**38 Portland St. - permit #2017-00884**

I have reviewed the information that you submitted with your permit application to legalize a dwelling unit on the second floor. At this point all the criteria is not being met and therefore I cannot approve the permit for zoning.

38 Portland St.
 FLOOR PLAN
 Scale - 1 block = 3 feet

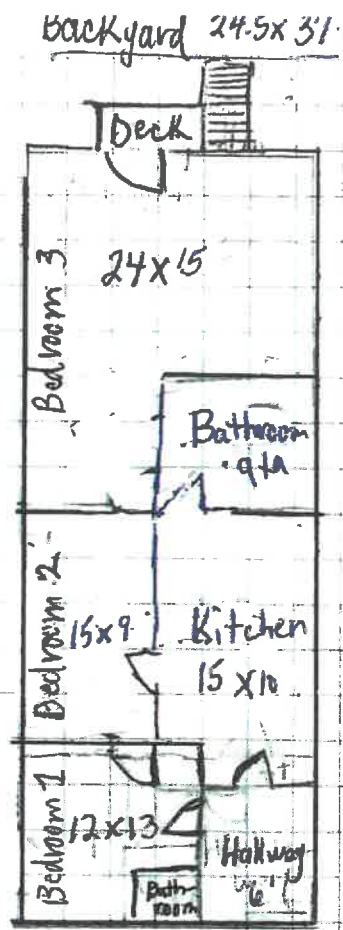
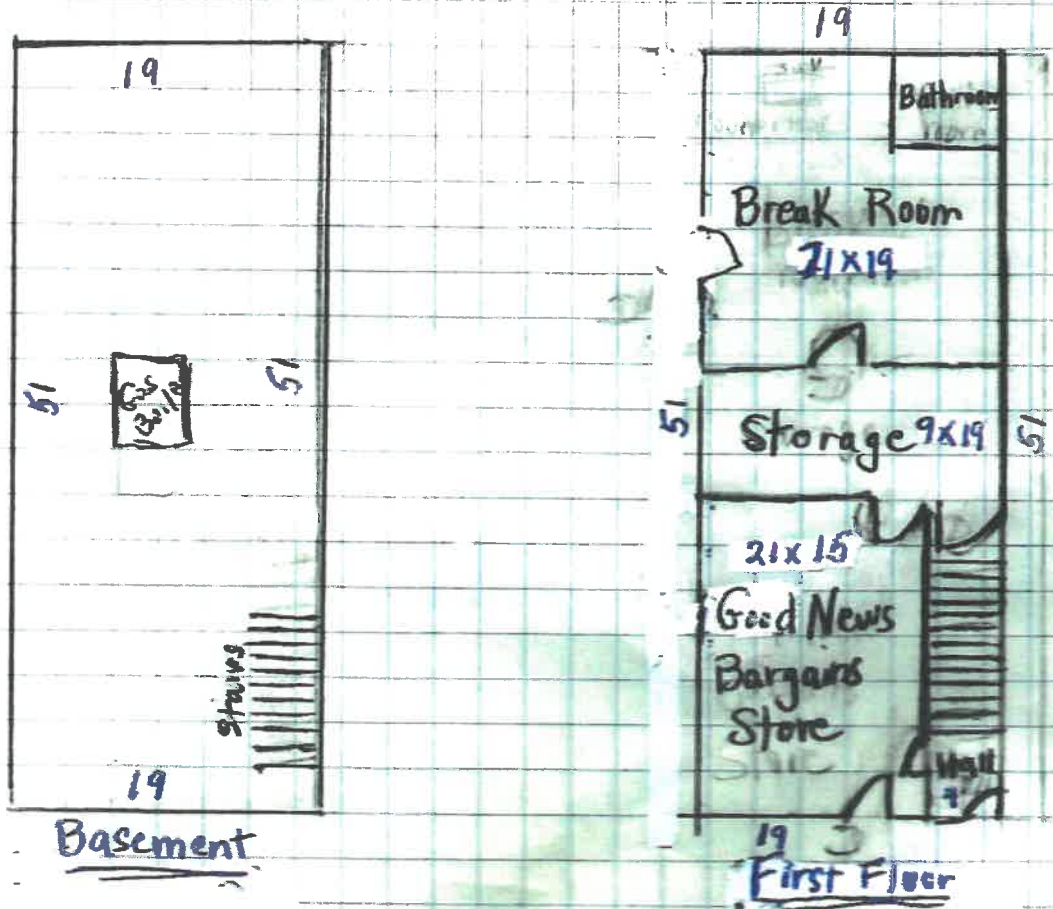
1. The bottom of the floor plan was cut off so it is not completely clear what the bottom two floor are, especially the left side one. Is that the basement? If so is the basement completely empty? Also the floor plans are supposed to be dimensioned. Please submit revised floor plans.
